A303 Sparkford – Ilchester dualling project

From Sarah Bucks, Chair, South Somerset Bridleways Association

7th. March 2019

Our comments for DEADLINE 4

FIGURE 2.5  
HAZLEGROVE JUNCTION UNDERBRIDGE  
GENERAL ARRANGEMENT

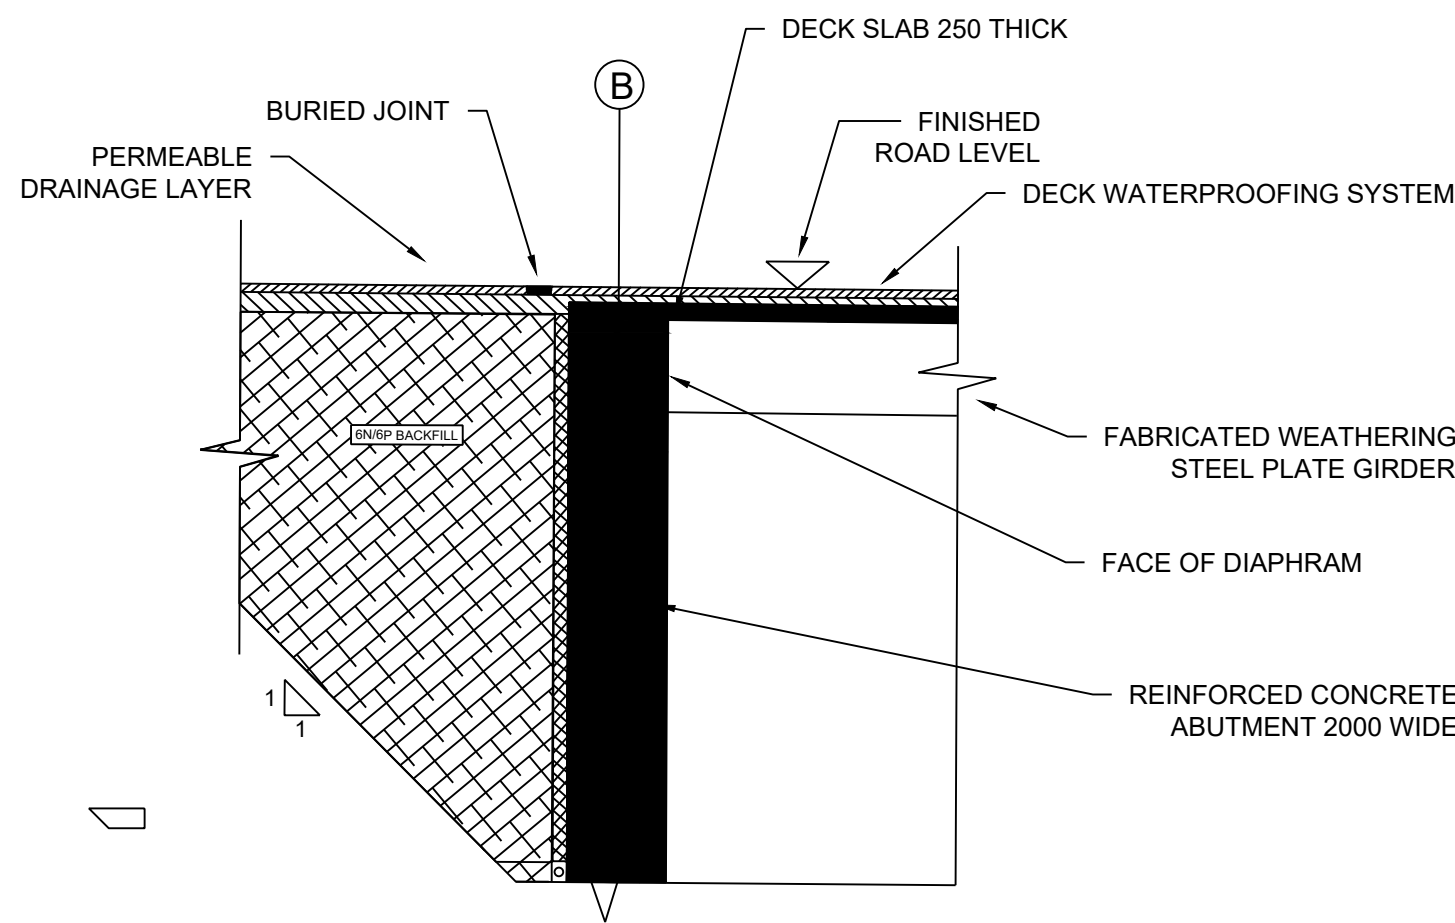
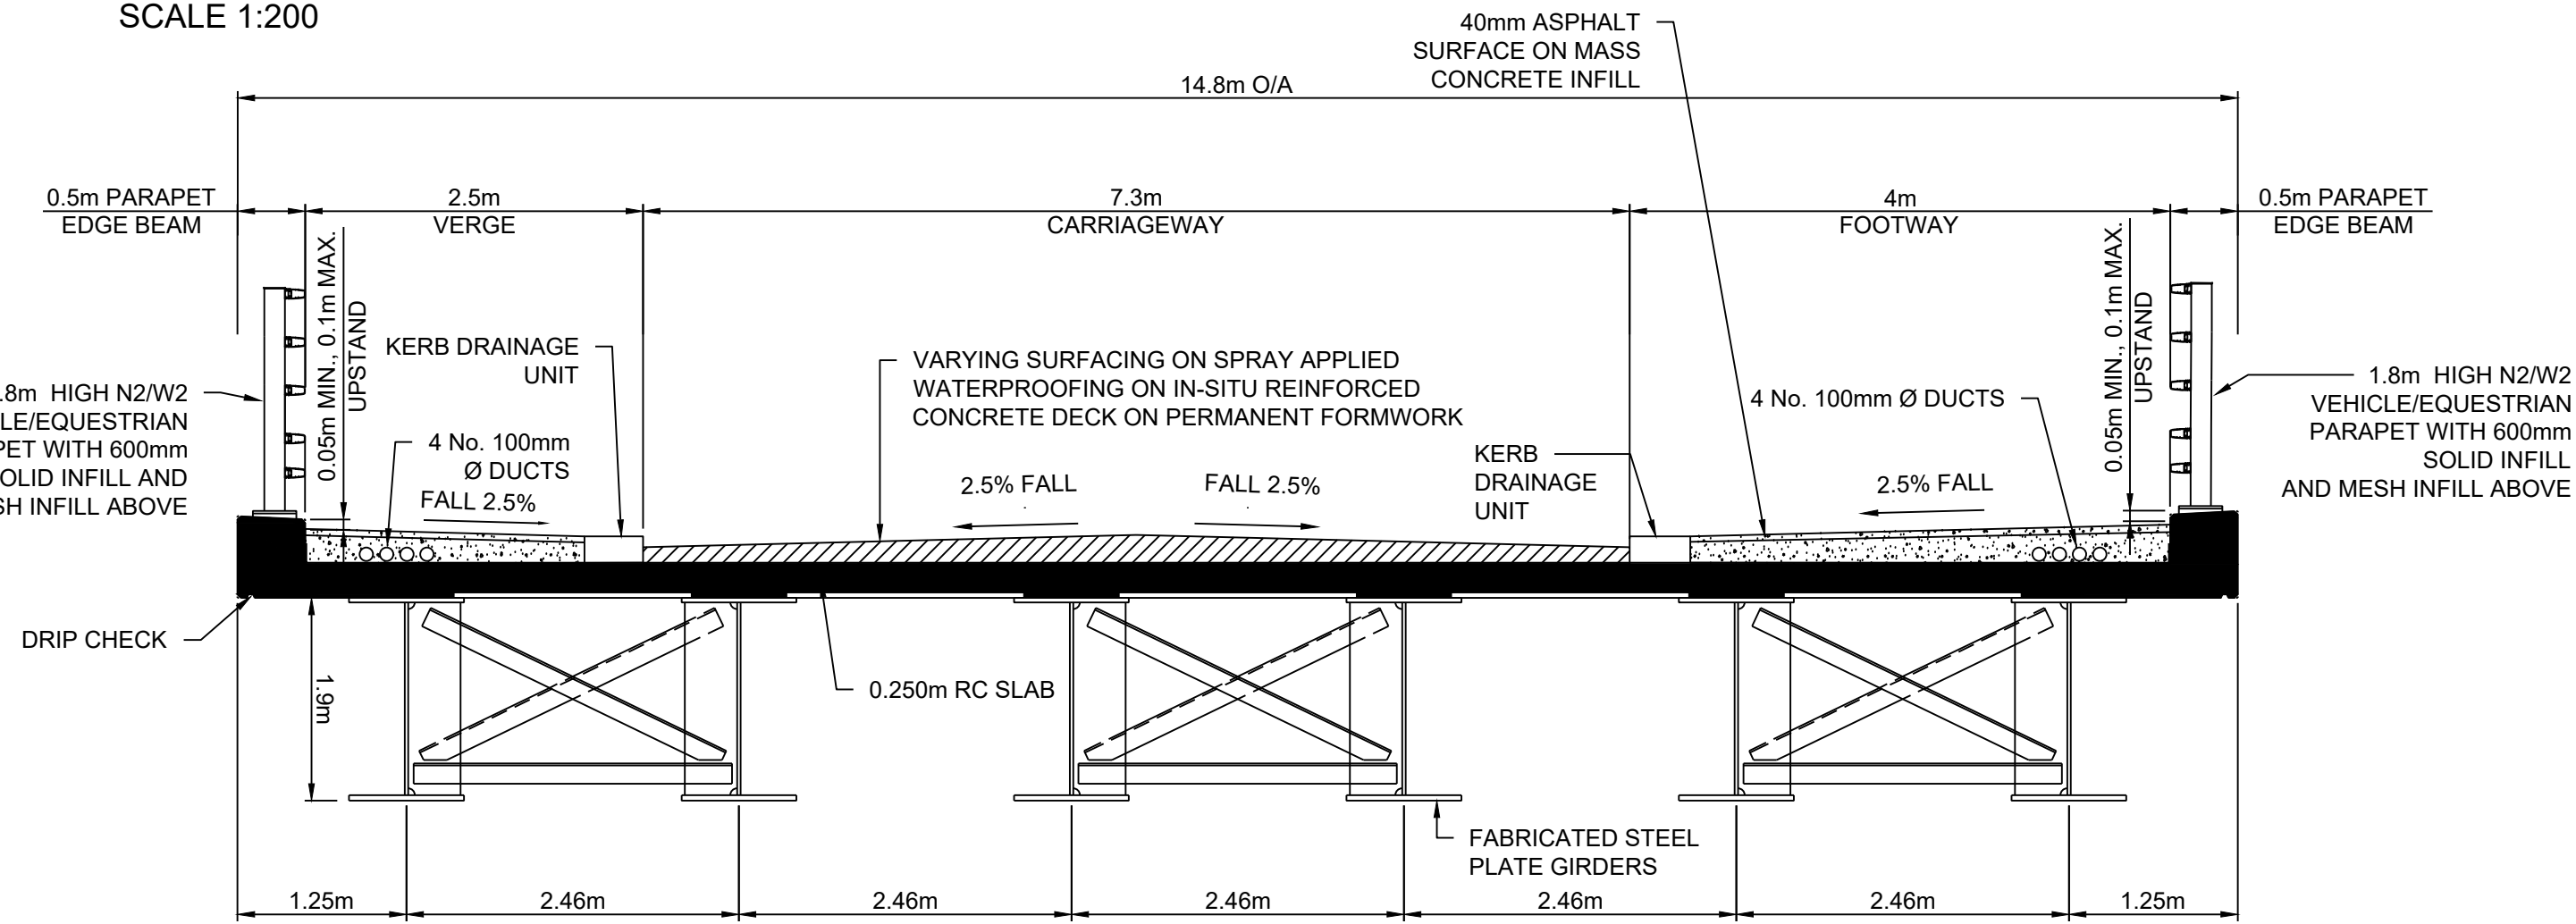
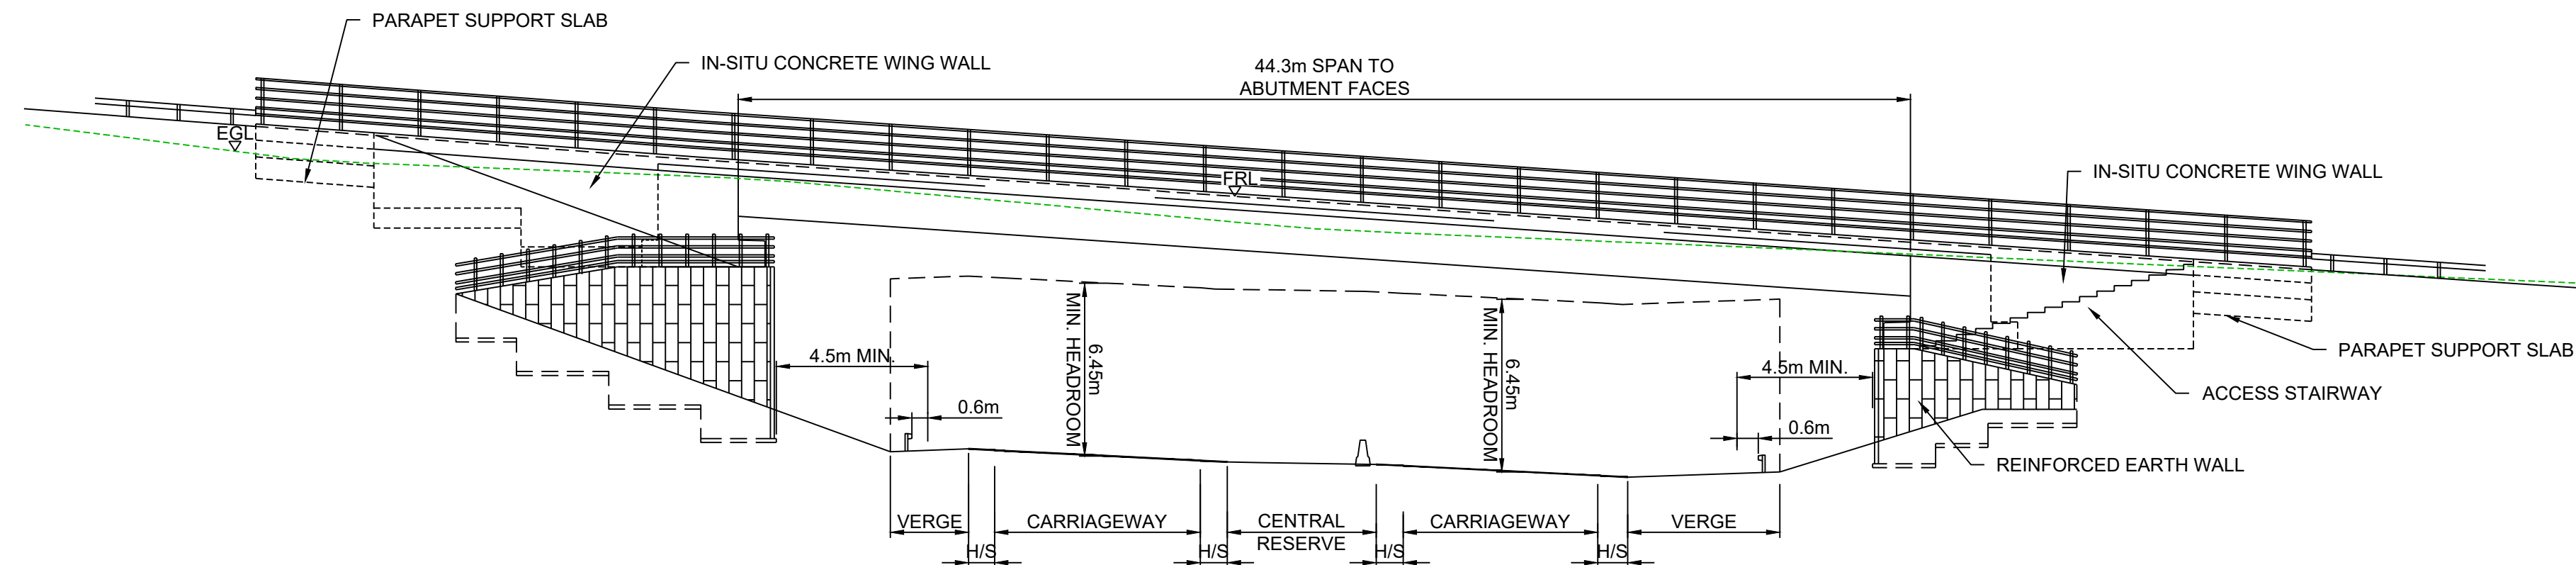
- The underbridge. This appears to be worrying many people, and might it be worth considering an overbridge for NMU users instead so they would not be sharing with the vehicular traffic. The design appears to show the underbridge having a distance of approximately 70 to 80 meters and this is going to be daunting for many. The image below is of a brideway underbridge – albeit not to a good specification as it is an upgraded footpath. This is located near Newcastle under the A189 and is said to be around 25 meters long. But the point is that in length it is approximately one third of the distance of the tunnel proposed for this Sparkford DCO scheme. Is it realistic to think that a 70 to 80 meter long underbridge would be safe for horse riders and other vulnerable road users, and sharing with vehicular traffic? I suggest that better alternatives could be achieved with an over bridge, or by positioning the tunnel at a different angle so the distance underground is shorter.

Ideally, the surface of the new carriageways near to and over the underbridge to the west of the Hazlegrave roundabout should be as quiet as possible to lessen the noise in the tunnel.

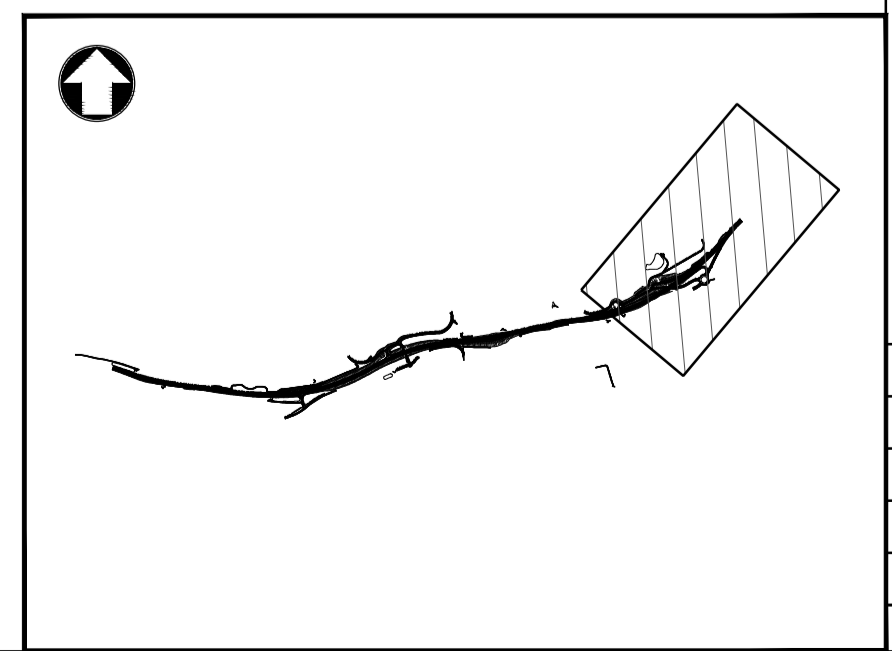
- Hazlegrove roundabout - create restricted byway rights in the verge alongside the motorised vehicular carriageway rather than oblige the horse riders and carriage drivers to mix with the vehicular traffic, including riding clockwise around the roundabout across the vehicular traffic coming on the 'off-ramp' from the westbound A303. If space in the verge is the constraint, would it be possible to shrink the southern side of the roundabout a little and allow more room in the petrol station verge? The NMU route should be two way, so four meters wide, from the Sparkford High Street, across the A359, and across the old A303 carriageway round to the underpass up to Hazlegrove School. This would remove the need for horse riders and carriage drivers to be on the main carriageway or crossing the off ramp from the new carriageway.

- Horse riders and carriage drivers will have to cross the A359 at the Hazlegrove roundabout, currently it is the only east – west route. Making provision for horse riders and carriage drivers in the design now is advisable. Although visibility is far from perfect, this crossing point will be used, and so some consideration should be given to it in the design. There is also a DMMO application in place for a bridleway around Ridge Copse (851 discussed later). One end of this bridleway is on the A359 across from the minor road from Weston Bampfylde, and thus, assuming the order is made and confirmed, is it likely that horse riders will be crossing the A359 a couple of hundred yards south of the junction with the Hazlegrove roundabout. Could consideration be given to a Pegasus crossing on the A359 where it meets the roundabout, or, if sufficient room can be found, for such a crossing to be further down the A359 from the roundabout, and horse riders could cross at that point, and not the point at the roundabout where the sight lines are not ideal.

Appendix 1 APPROPRIATE MITIGATION FOR STOPPING UP OF TERMINUS OF BRIDLEWAY Y 30/28 (EASTMEAD LANE)

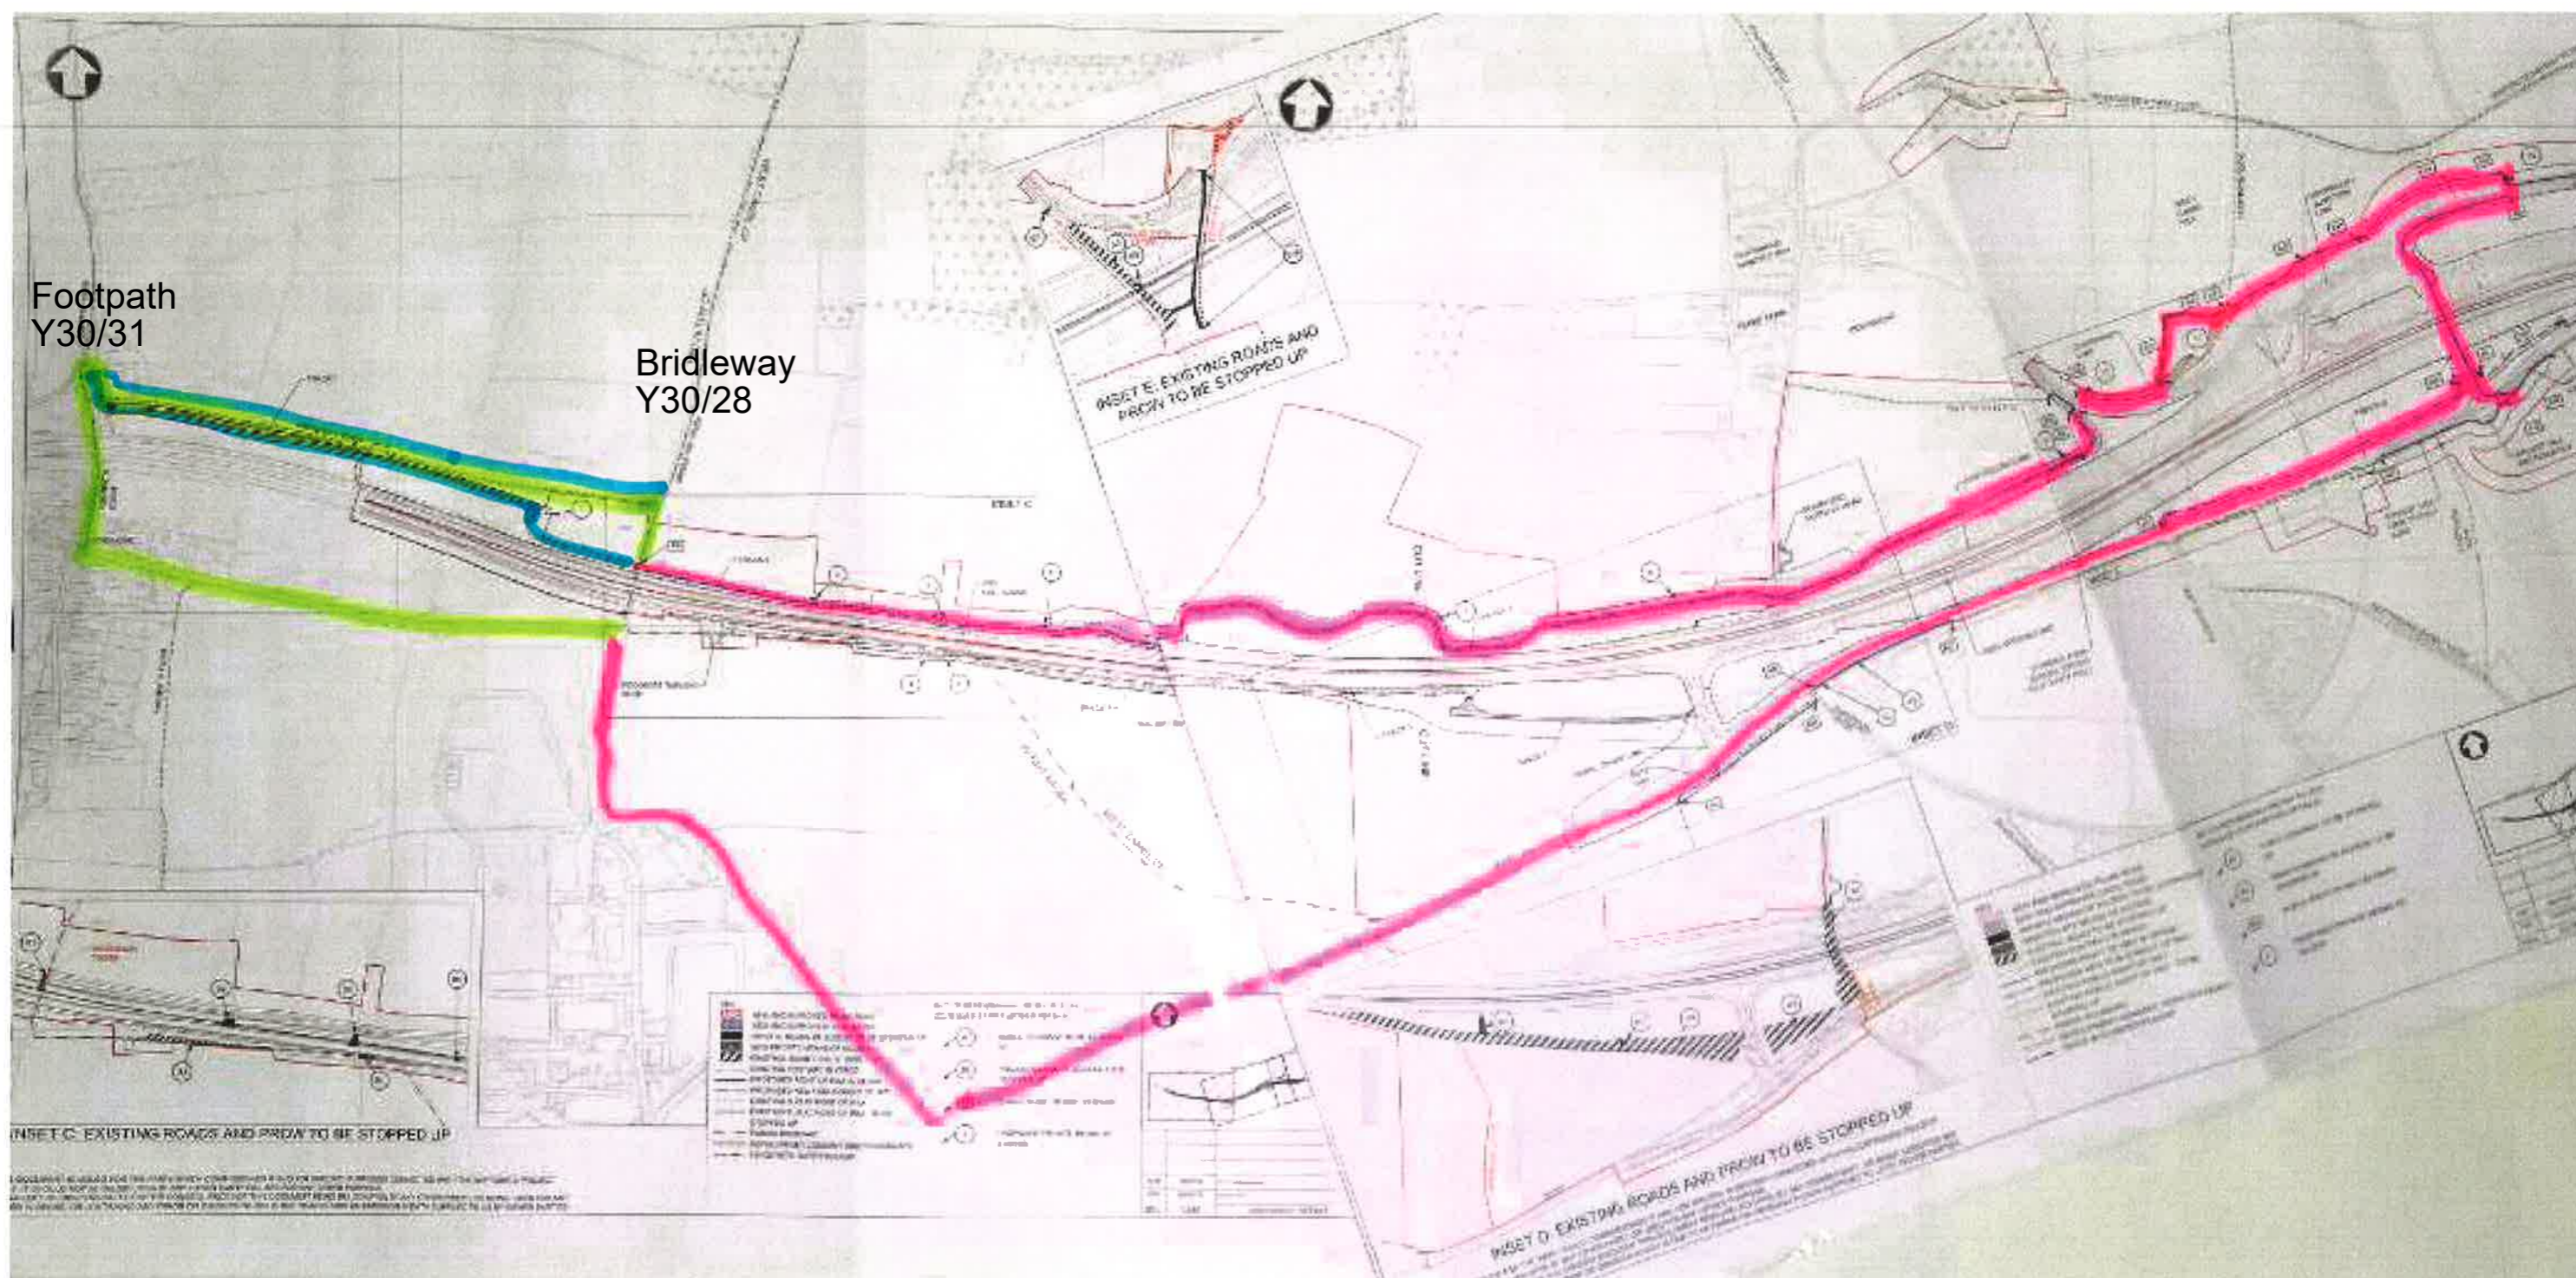
- **Podimore to Eastmead Lane and Cary Fitzpaine** - incorporating the overbridge at Podimore is the obvious answer for horse riders, carriage drivers, cyclists, and disabled using ‘tramper’ type vehicles. Walkers and others might benefit from a pedestrian overbridge at the southern end of Eastmead Lane, but the Podimore overbridge is already in place and capable of carrying vehicles. We do understand that the Podimore bridge is outside the DCO envelope, and that HE is considering the possibility of using their ‘Dedicated Funds’ to help find a solution. If the land to the east of Podimore bridge, which is inside the red line envelope is being acquired outright, rather than on a temporary possession basis, could consideration be given to creating a restricted byway along the southern side of the hedge on the northern side of this field, which would pass the new drainage ponds and connect up to Eastmead Lane. This would remove the need to solve the conundrum of the Y20/30 bridleway.

- Move the bridleway (Y30/29)³ to the southern side of the hedge and upgrade it to a restricted byway. (Using Track 1). This bridleway is shown on the HE scheme plans as an existing bridleway. There is a DMMO application to upgrade the section of Eastmead Lane which is not already a restricted byway to restricted byway status. (see section 4 below). If the rights on Eastmead Lane are shown to be of restricted byway status, then HE should provide a restricted byway to join Eastmead Lane with Podimore.
